**SSD 7349 – Resource Recovery Facility at the properties Nos.51-57 Violet Street in Revesby
Canterbury-Bankstown Council's submission**

Thank you for the opportunity to provide comments on the Environmental Impact Statement (EIS) for the proposed expansion of the resource recovery facility at the properties Nos. 51 -57 Violet Street in Revesby.

Client	ENVIRO RECYCLING
Project	WASTE RECYCLING FACILITY NOS 51 & 57 VIOLET STREET, REVESBY
Title	CATCHMENT PLAN

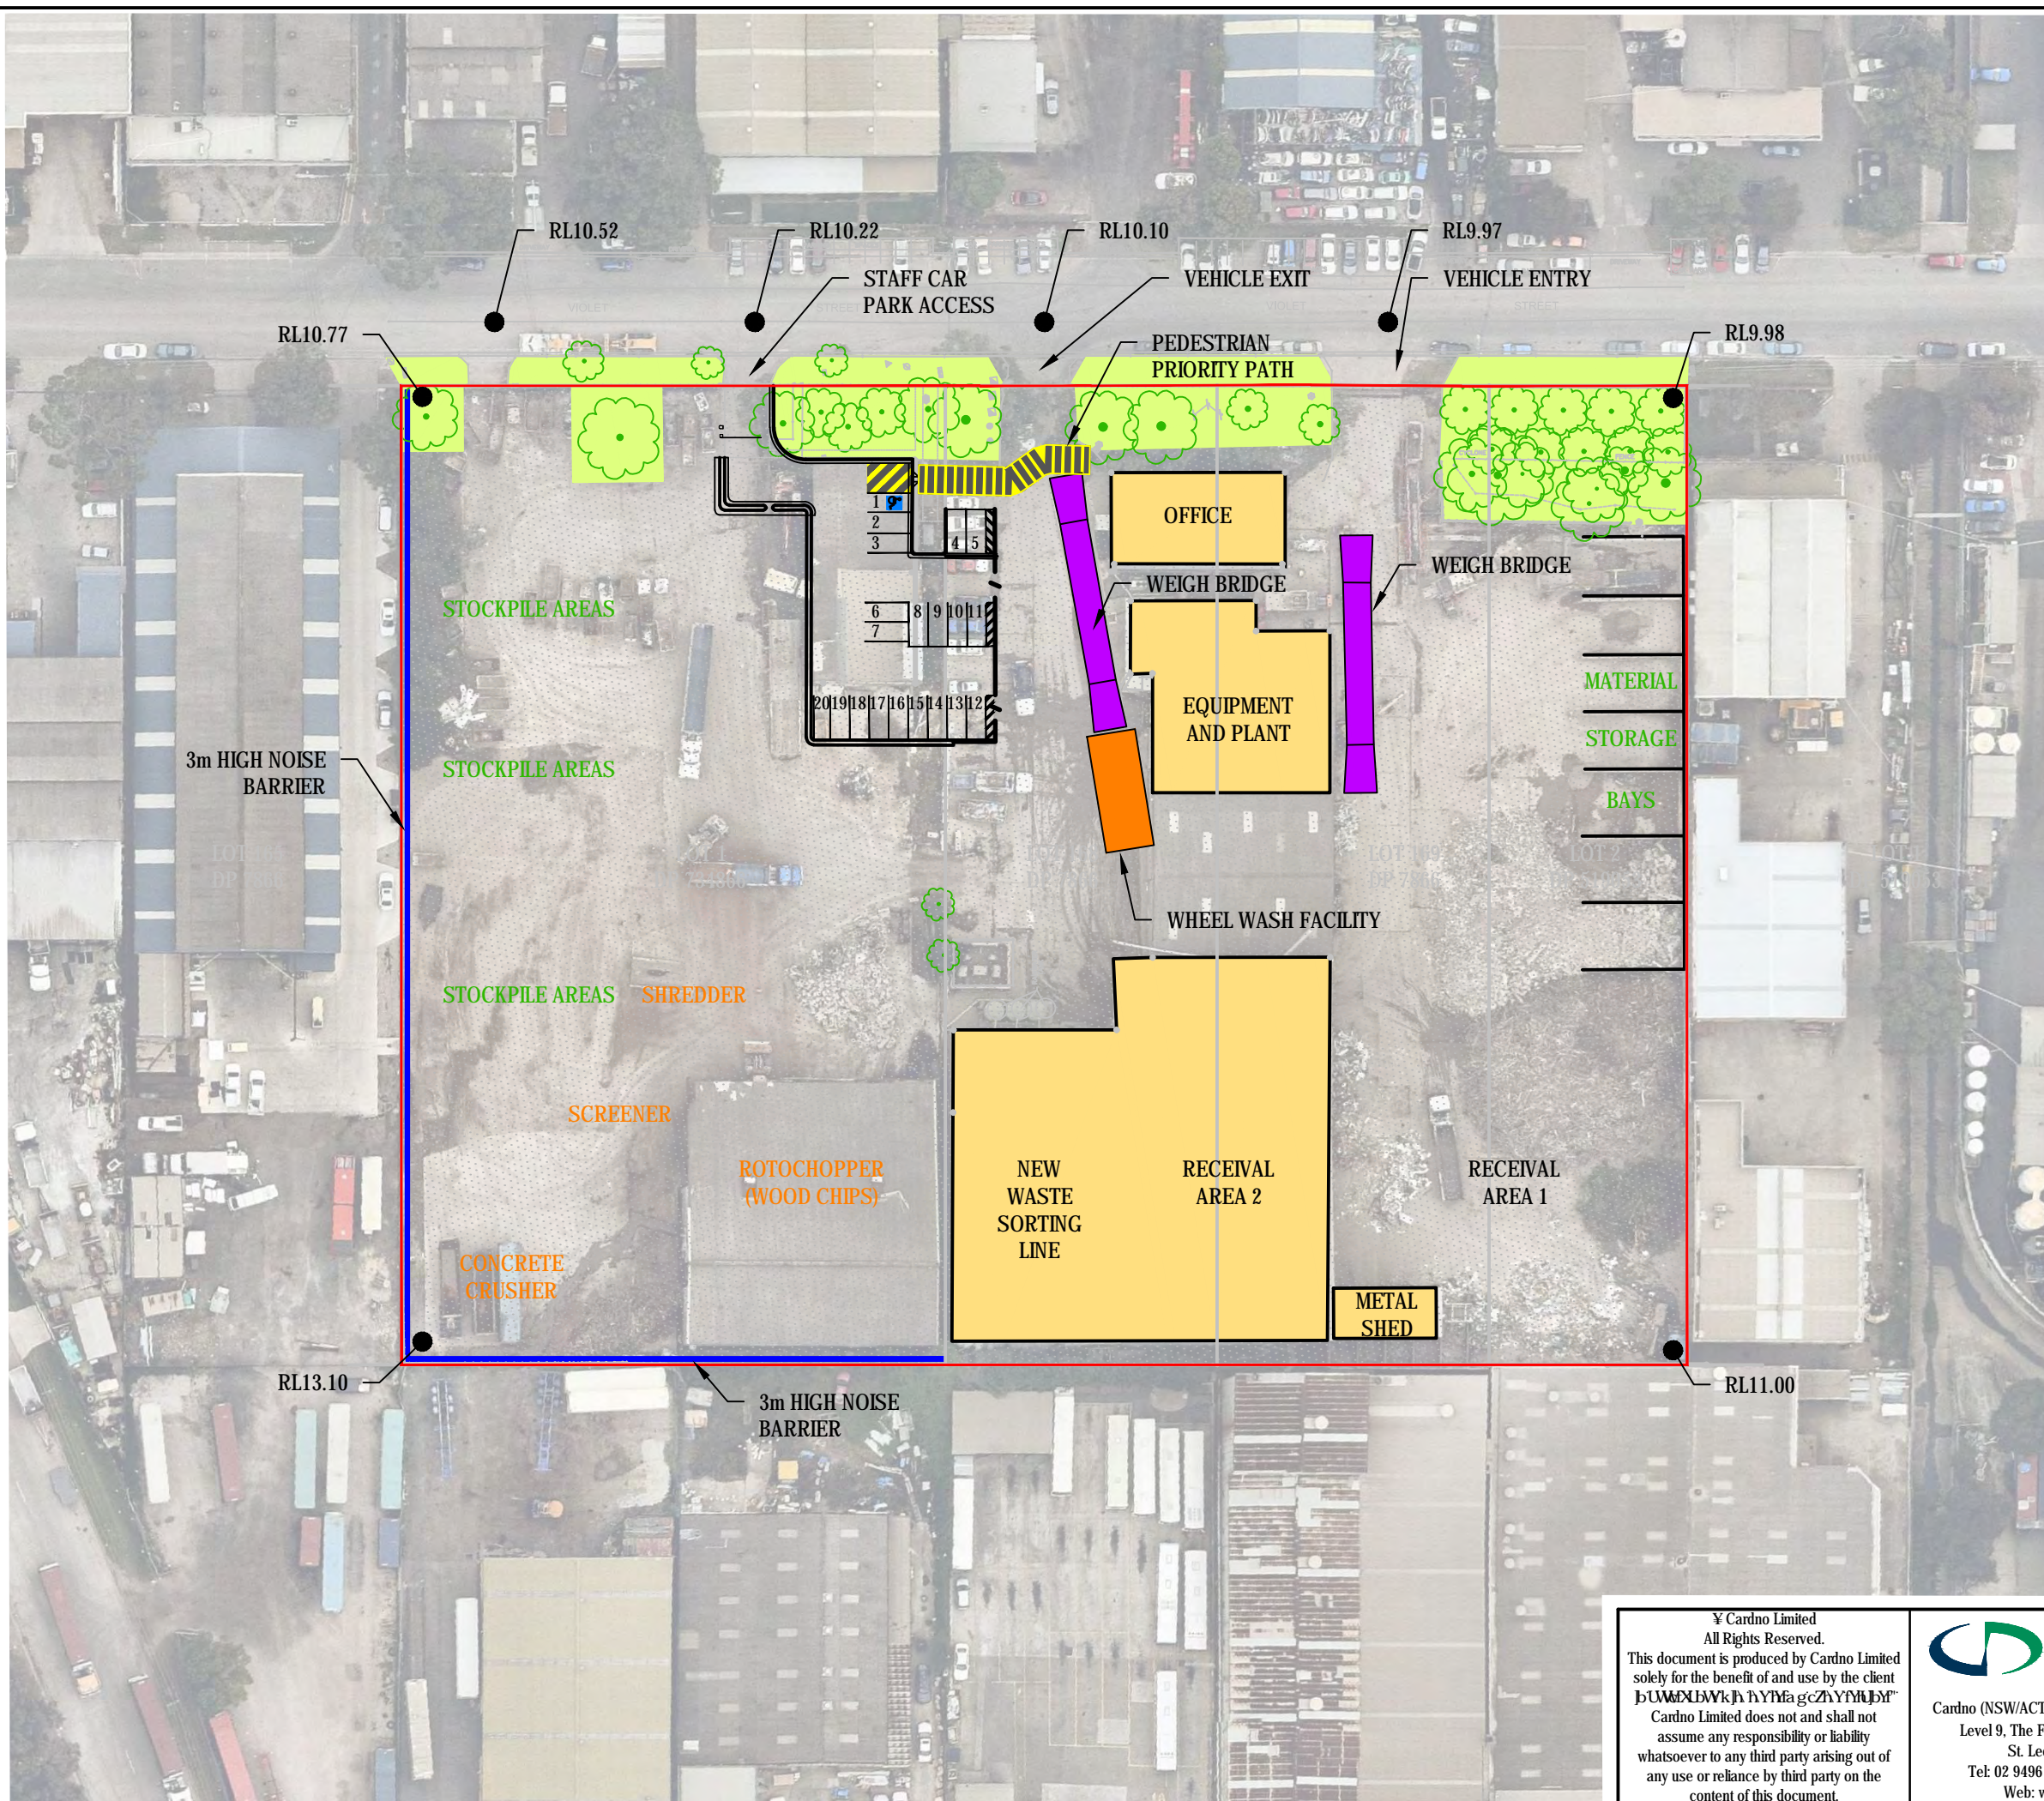
In light of the proposed increase in the resource recovery capacity of the site, Council seeks an upgrade of the existing oil and grip separator in Catchment 2, which has low to medium

treatment effectiveness to meet with the water quality targets set out in the GRCZMP. Council suggests upgrading the existing grip separator with the vortcapture GPT.
